OFFICIAL NOTICE OF DECISION

CITY OF ALBUQUERQUE
PLANNING DEPARTMENT
DEVELOPMENT REVIEW BOARD

Project# 1007963

12DRB-70149 EXT OF MAJOR PRELIMINARY PLAT

**PLAT OF**  
**LOT'S 20-A AND 20-B**  
**ROMERO ADDITION**  
 PROJECTED SECTION 17, TOWNSHIP 10 N., RANGE 3 E. N.M.P.M.  
 TOWN OF ALBUQUERQUE GRANT  
 BERNALILLO COUNTY, NEW MEXICO  
 JULY 2015

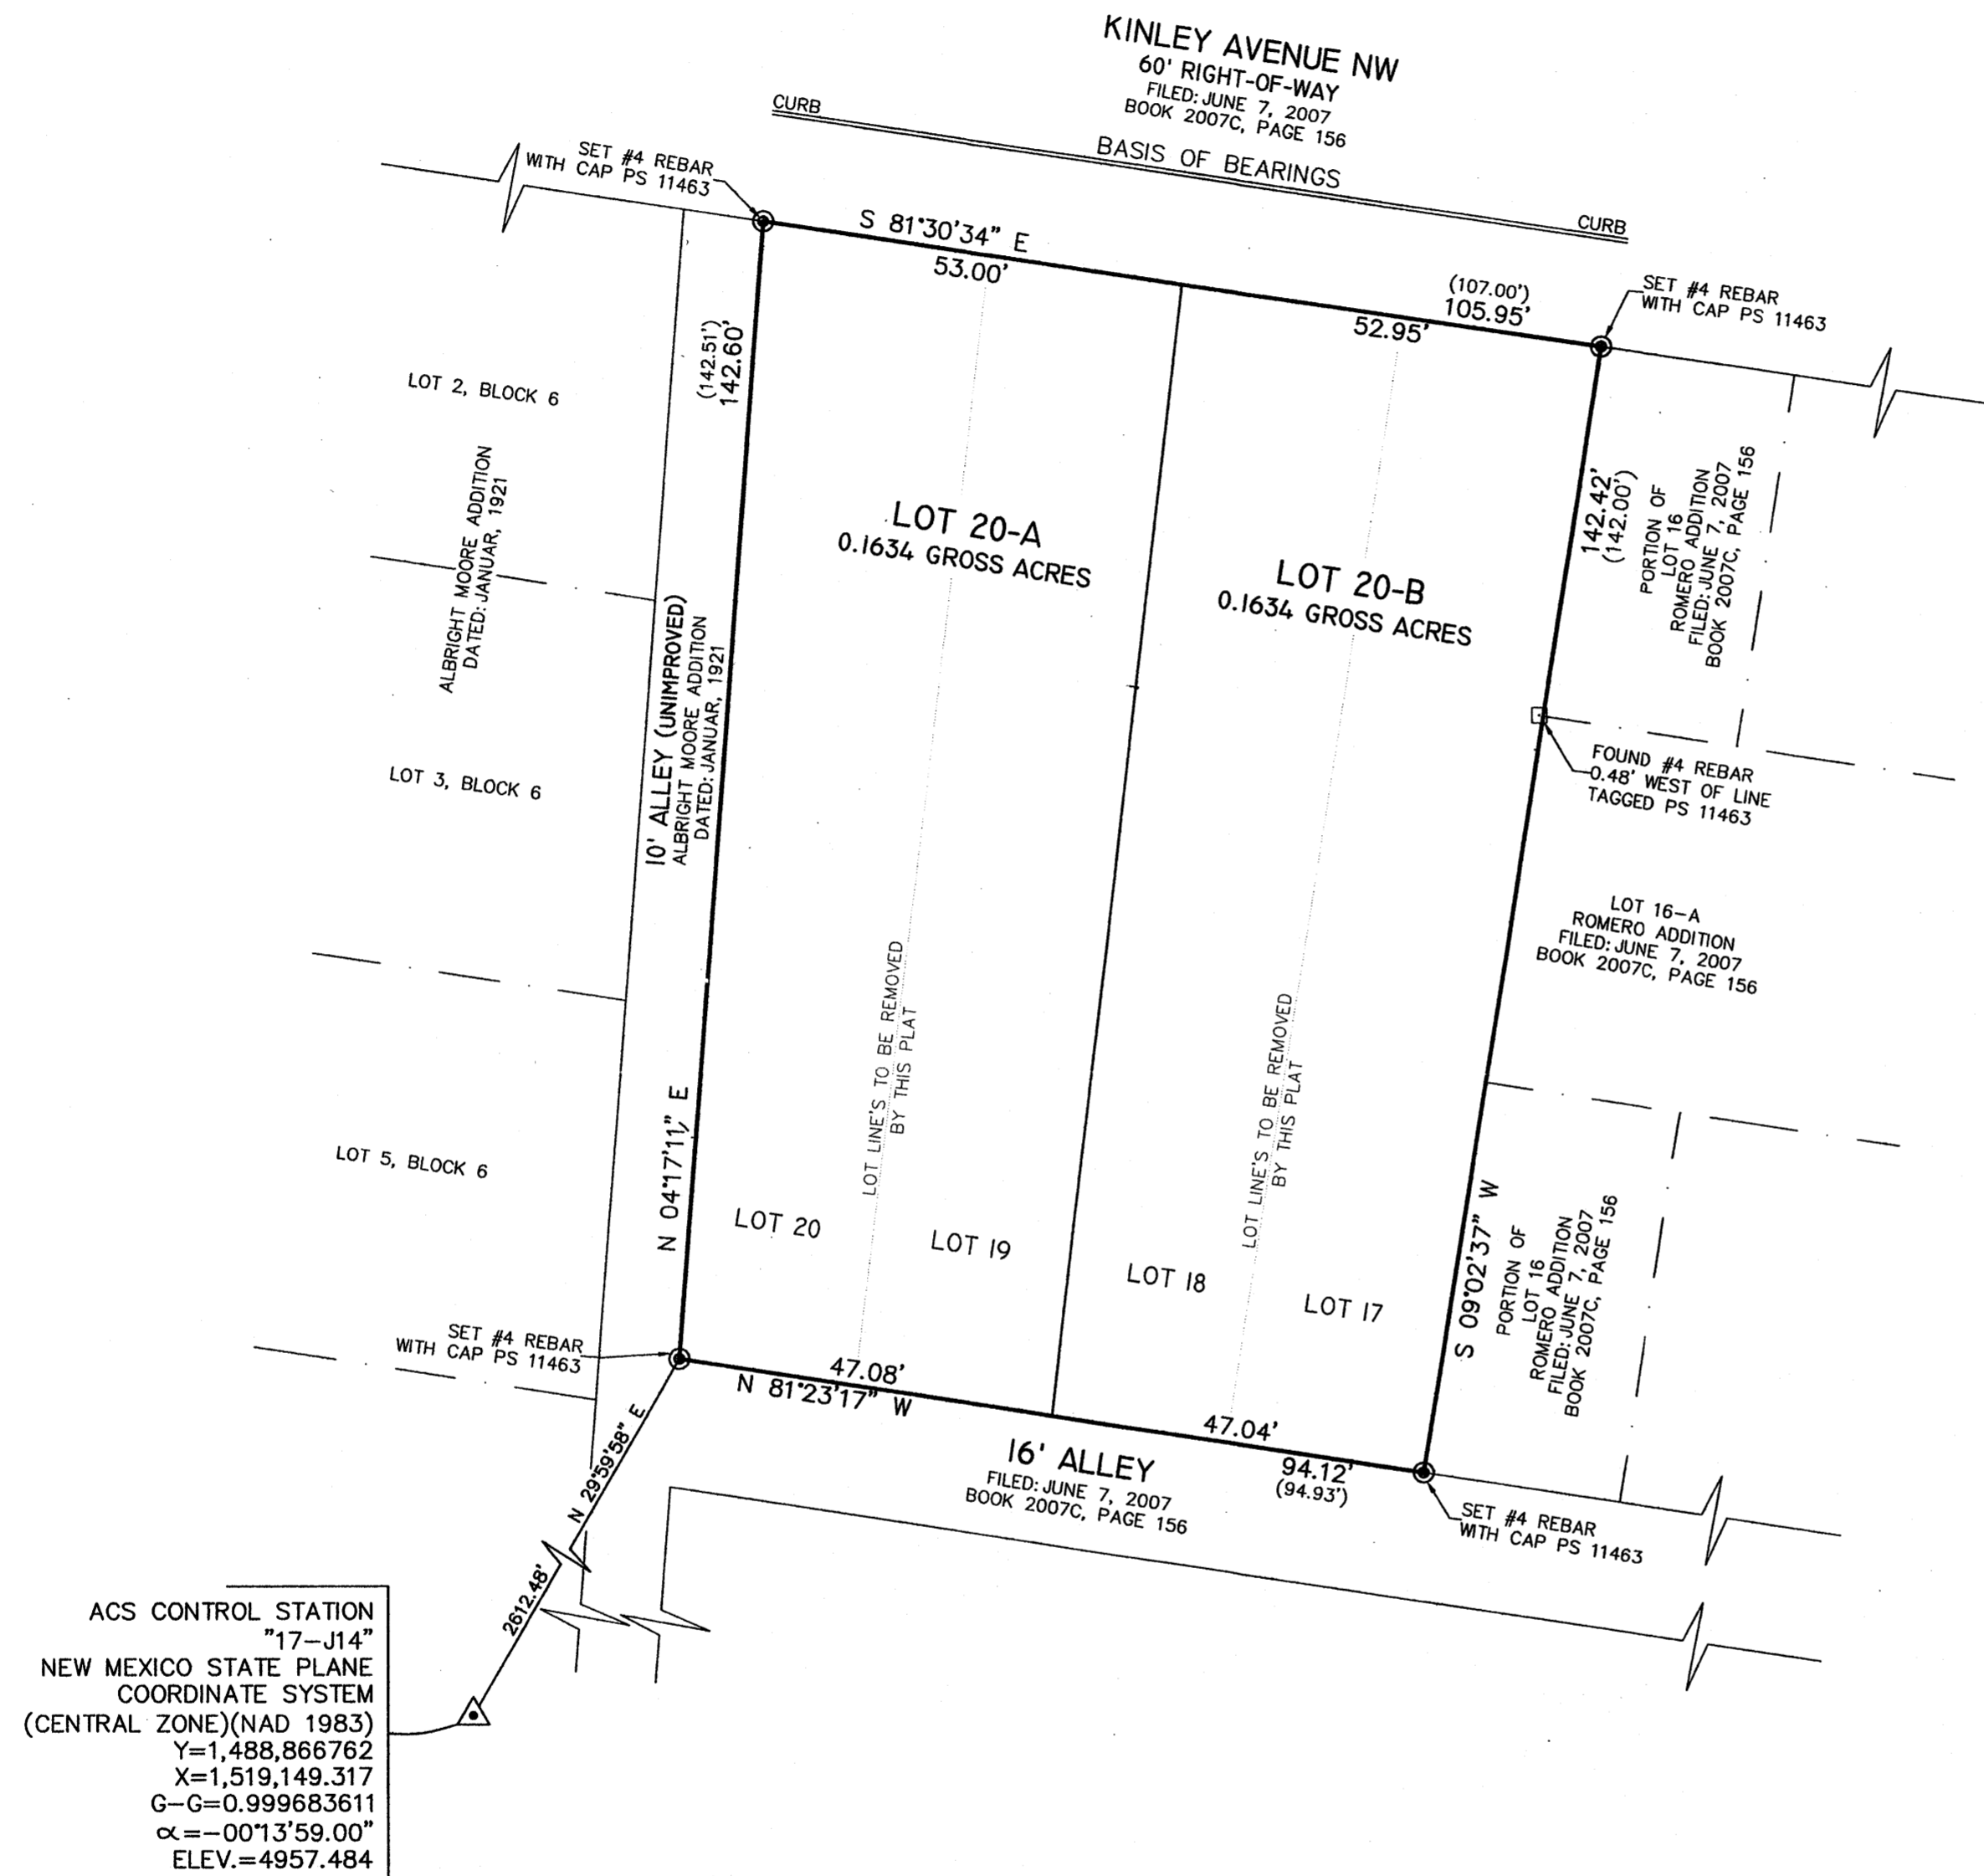
The subject site is zoned SR and is within the Sawmill Wells Park Sector Development Plan area; R-LT regulations generally apply for new development with exceptions and design regulations noted in the sector plan. The sector plan does allow 35 foot by 100 foot lots, but "Lot Area" is defined by the Zoning Ordinance as exclusive of easements for a private way or thoroughfare [§ 14-16-1-5].

It appears the most effective development would be to vacate the adjoining north-south alley and plat 3 lots with frontage on Kinley.

**PROPOSED PLAT OF  
LOTS 17-A, 18-A, & 19-A  
BLOCK 3, ROMERO ADDITION**  
PROJECTED SECTION 17, T. 10 N., R. 3 E., N.M.P.M.,  
TOWN OF ALBUQUERQUE GRANT  
CITY OF ALBUQUERQUE, BERNALILLO COUNTY, NEW MEXICO  
MAY, 2010

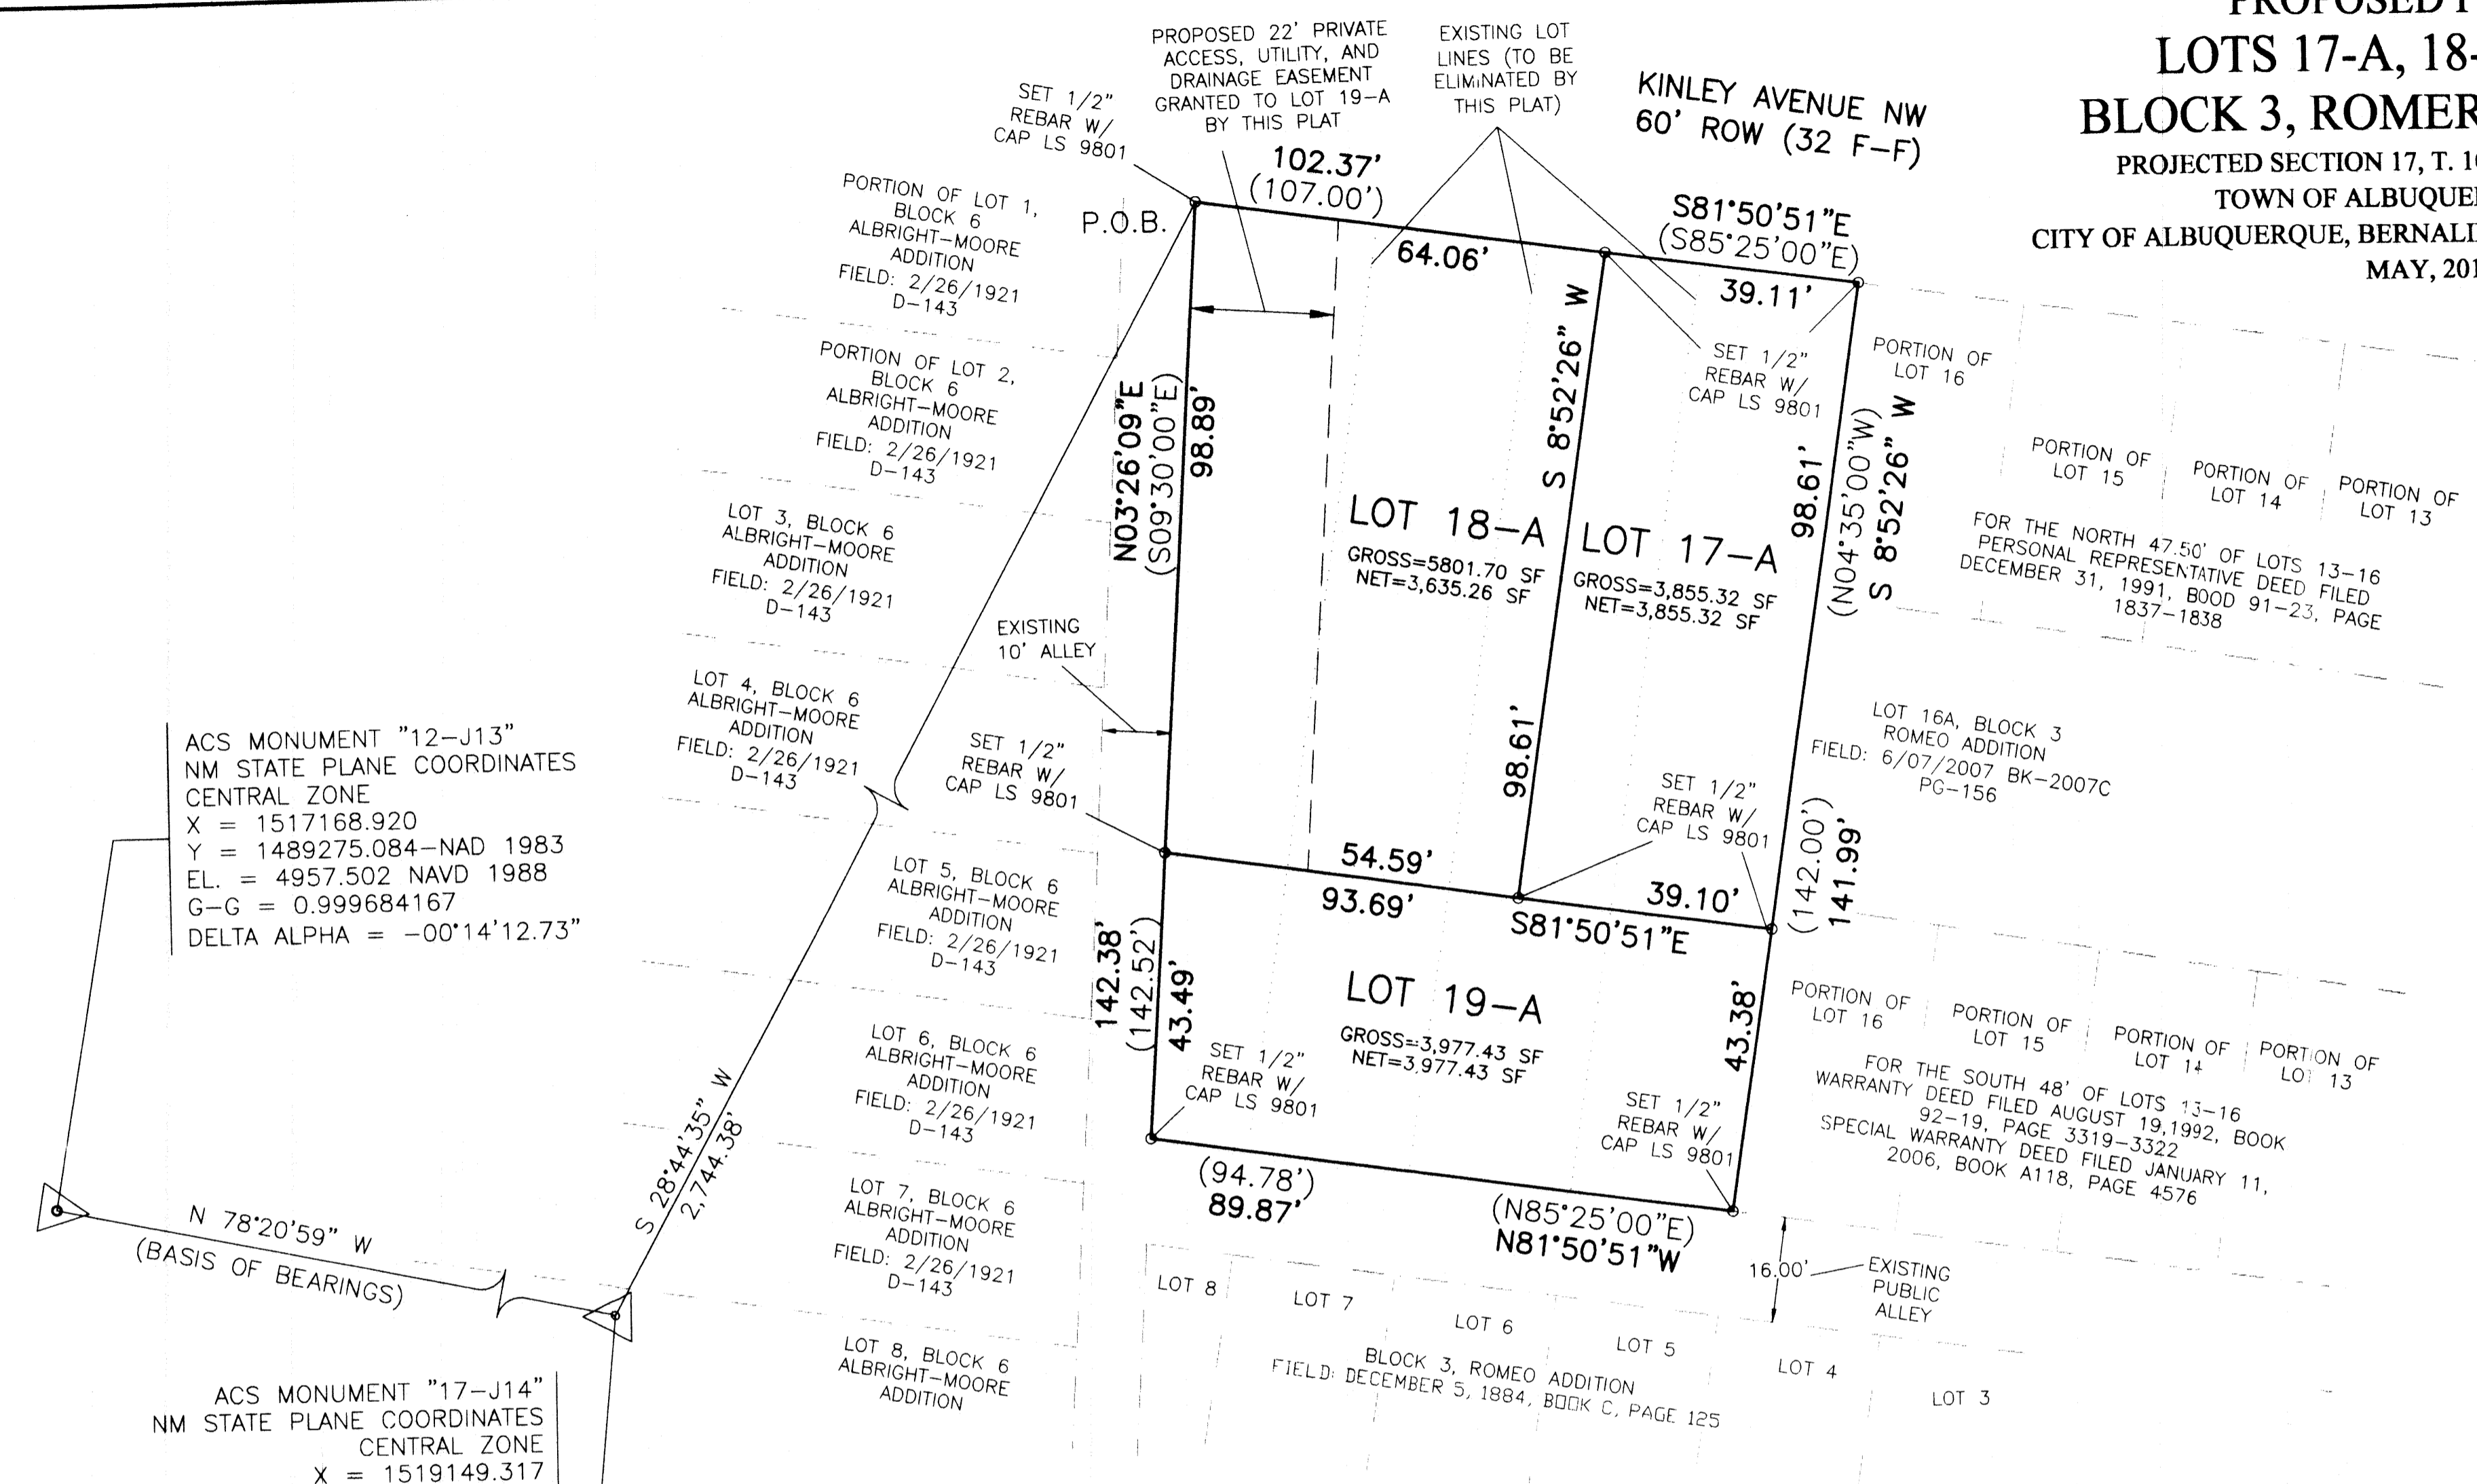
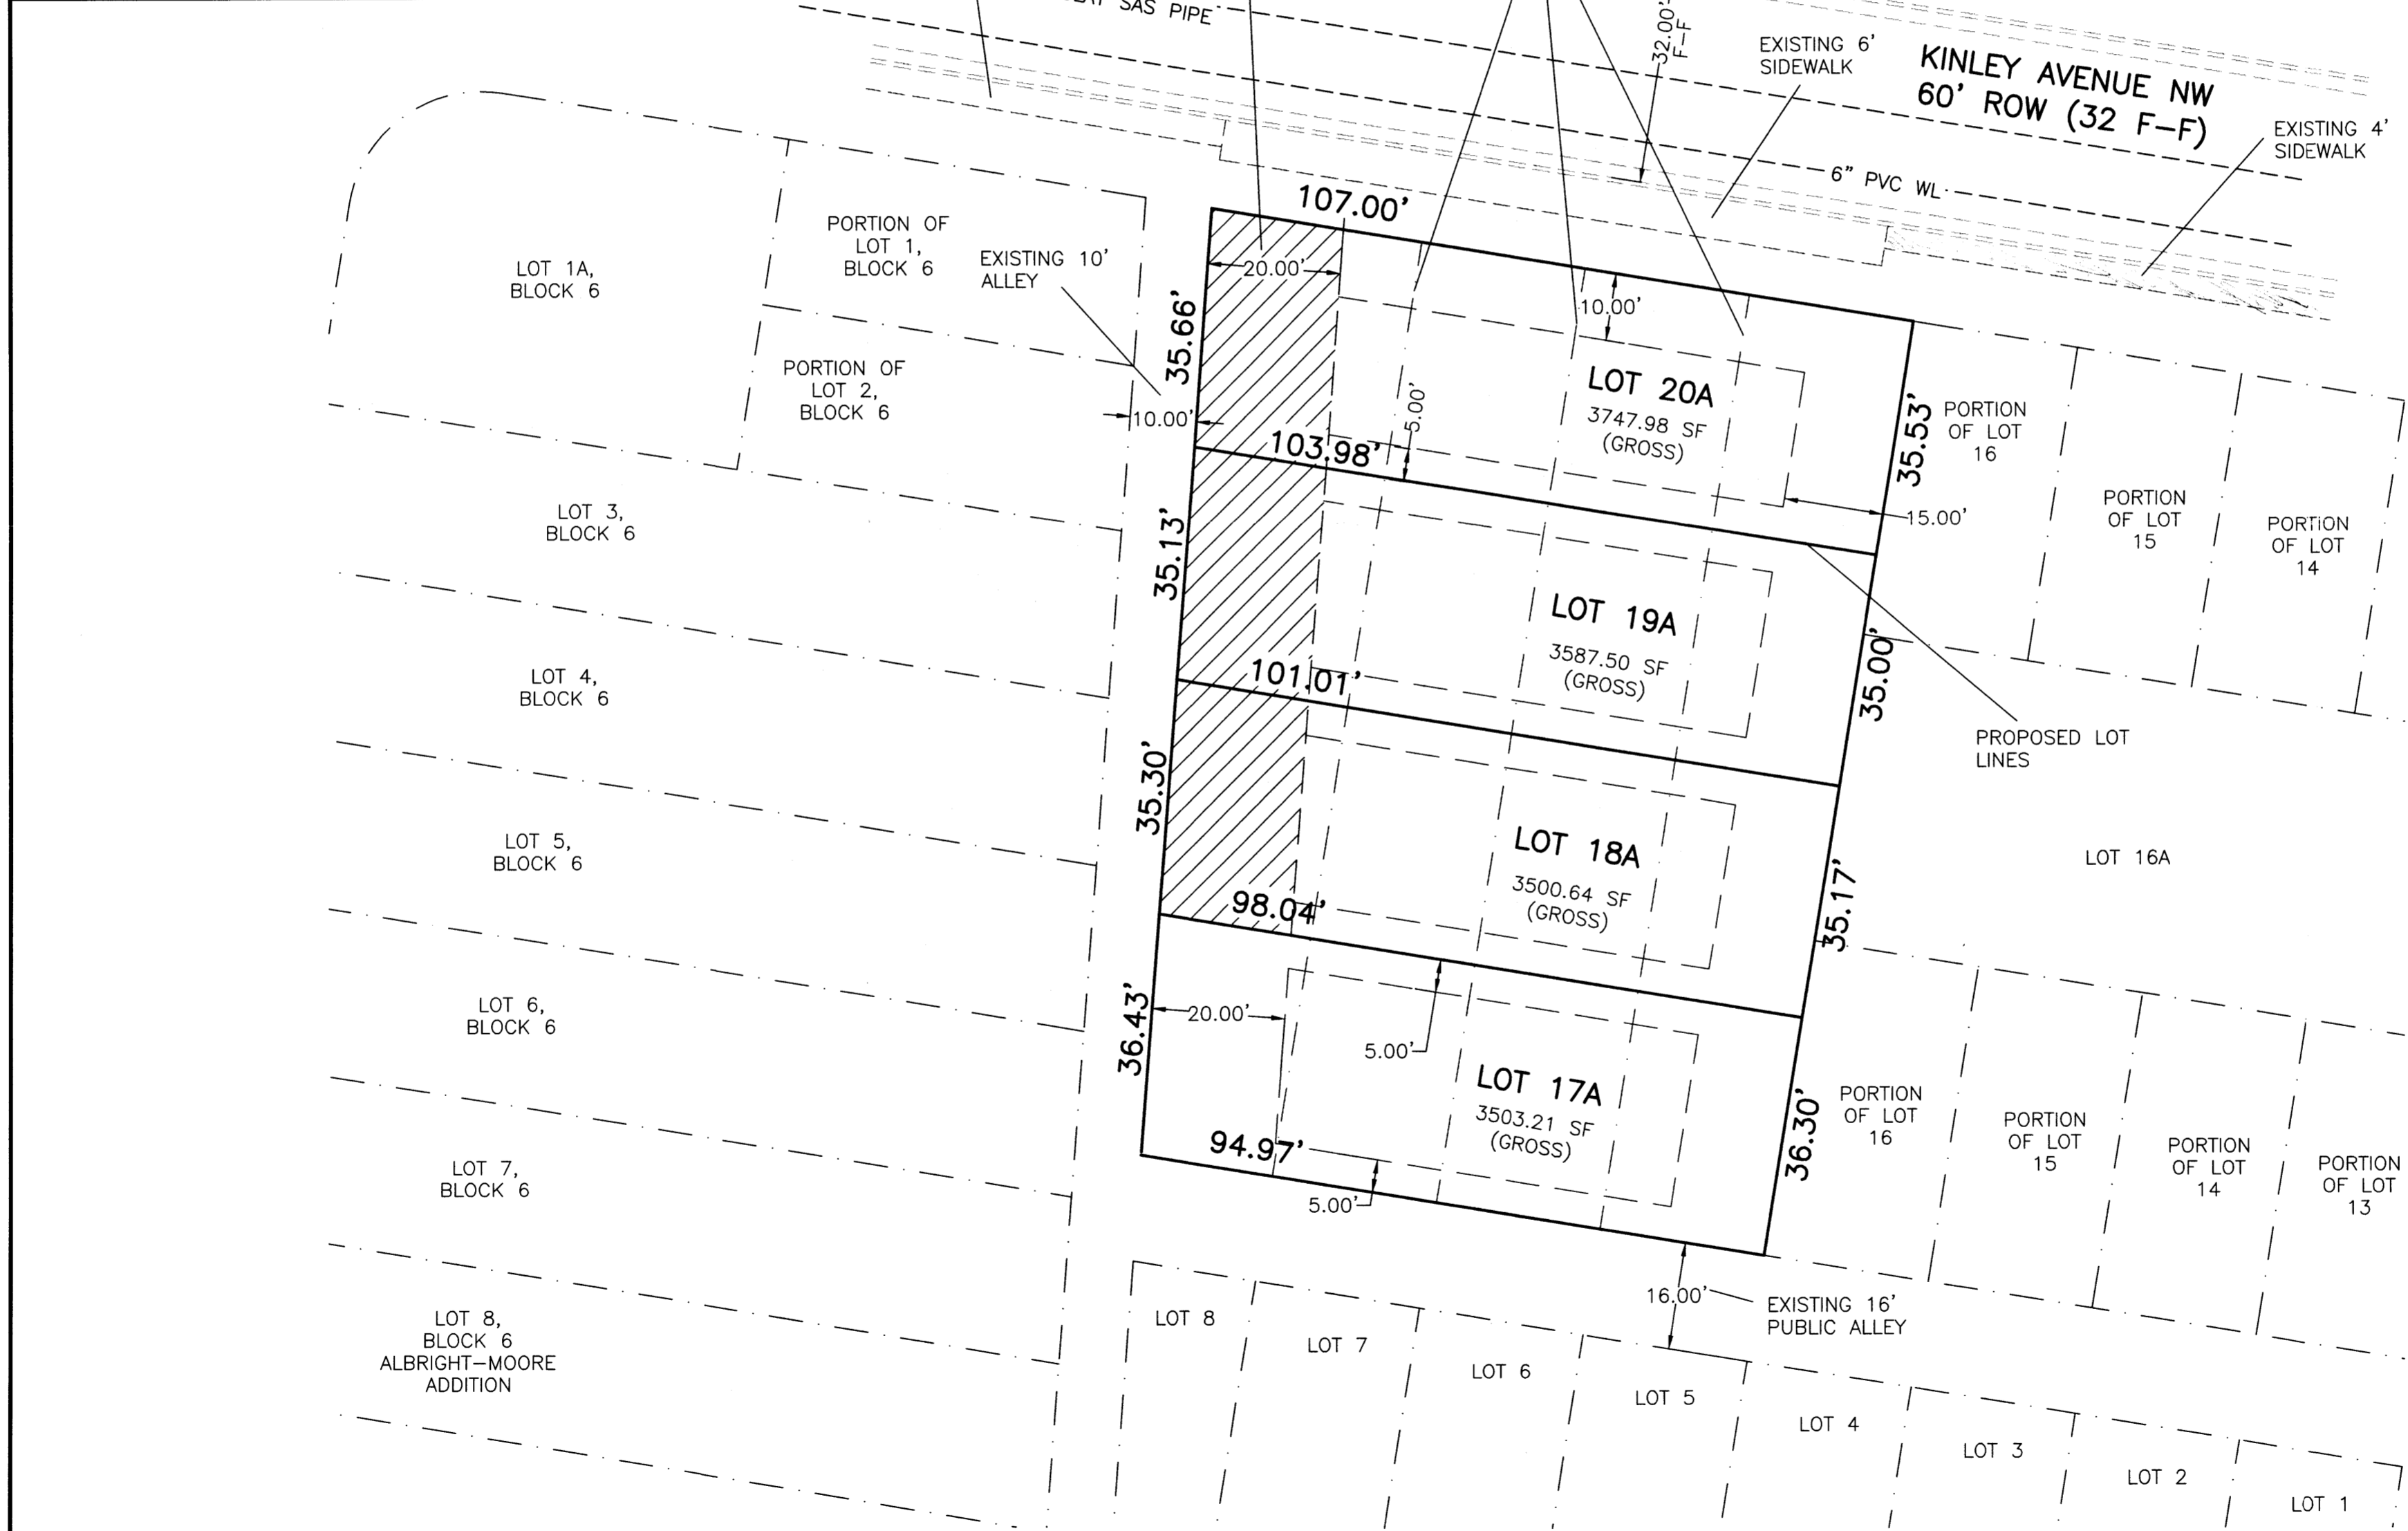
Provide an exhibit showing the location of sidewalk and defining the distance from face of curb to the property line. Right of way dedication may be required.
Define the maintenance responsibilities for the private access easement.

The subject site is zoned SR and is within the Sawmill Wells Park Sector Development Plan area; R-LT regulations generally apply for new development with exceptions and design regulations noted in the sector plan.
